Online Comment

Application H09-0253-22
Location Plot 9 South Lincolnshire Food Enterprise Zone Off A151 Holbeach
Proposal Details of surface water drainage, scheme to deal with contamination and foul water strategy (Conditions 6, 8 & 12 of the LDO)

Name Sue Armour
Address Environmental Protection Officer SHDC

Drawing Number: 21-L74-C008B Revision:

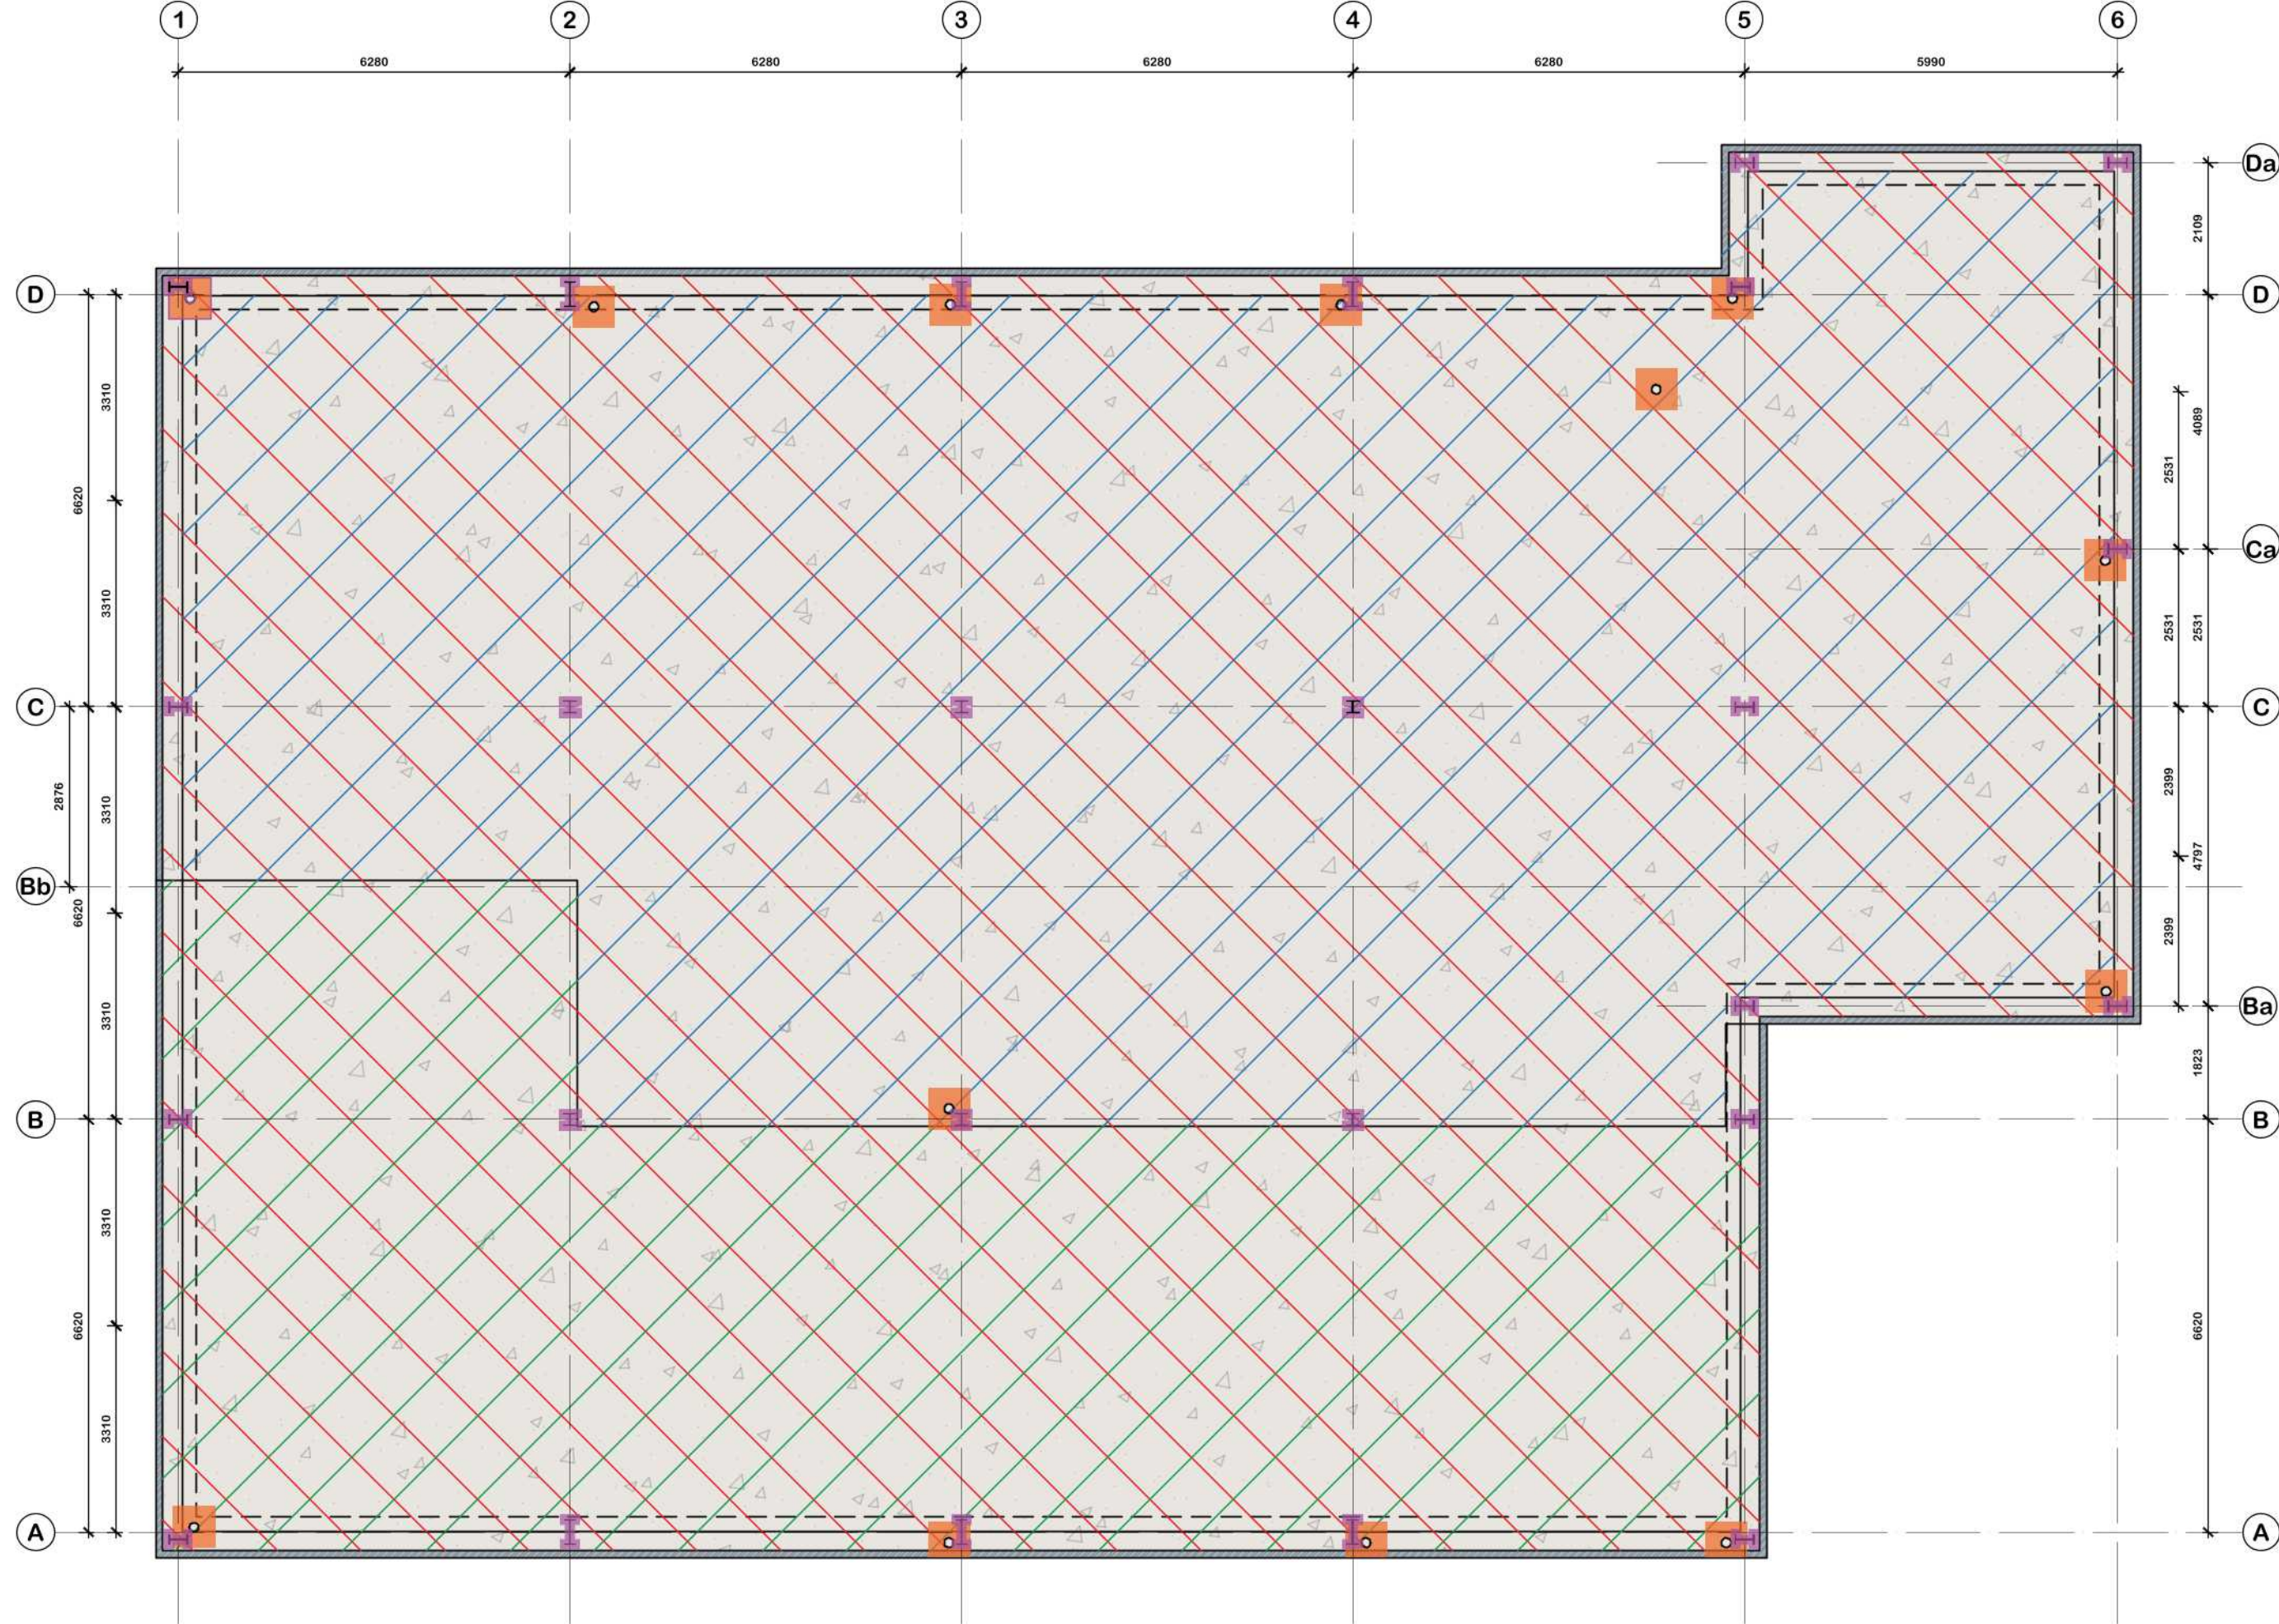
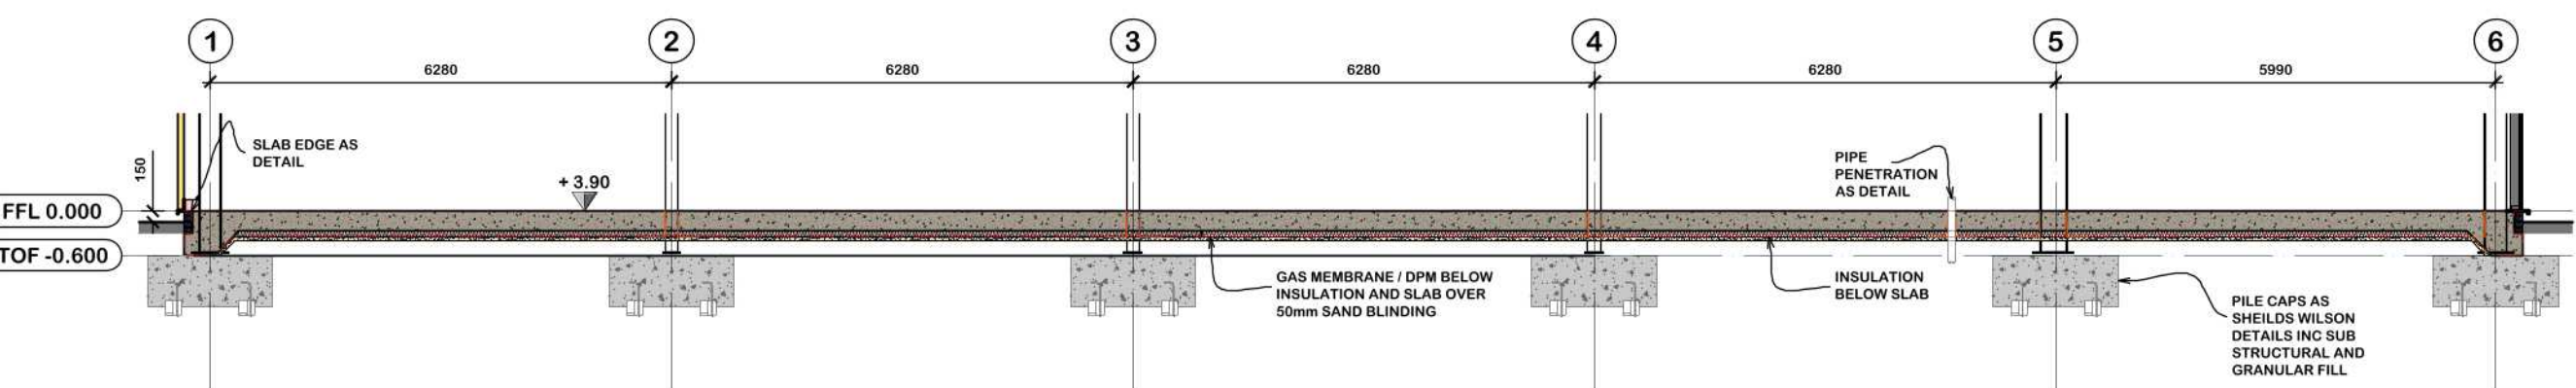
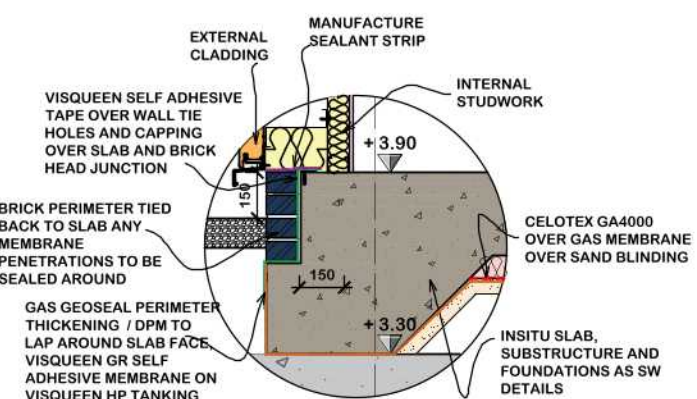
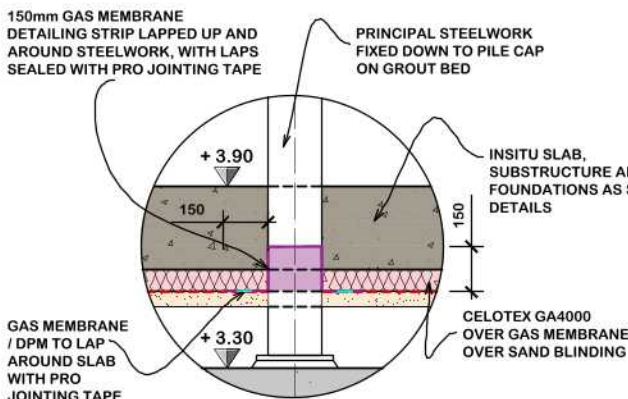
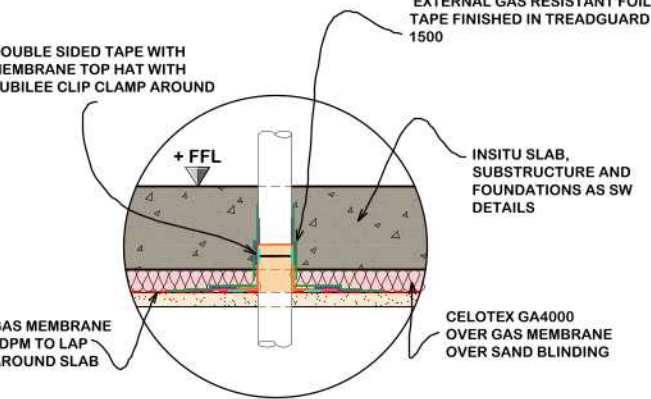
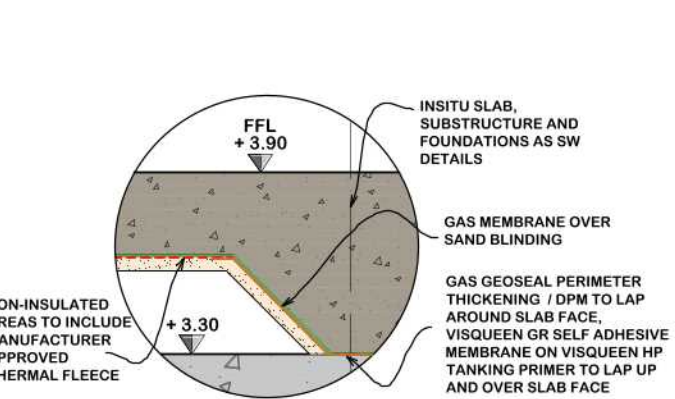
I have reviewed the Envirosolution 'Remediation Strategy & verification Plan Holbeach Food Enterprise Zone, Land off A151, Spalding, PE12 7BF' Document ref CL102 version 2 dated 11th May 2022, Trundley Design services drawing ref 21-L74-C008B and the Viscqueen Gas Barrier Technical datasheet - Onsite usage and am in general agreement with the findings. This would satisfy part 8iii of Schedule 2 of the Holbeach FEZ LDO conditions for plot 9 and I look forward to receipt of the validation report in due course.
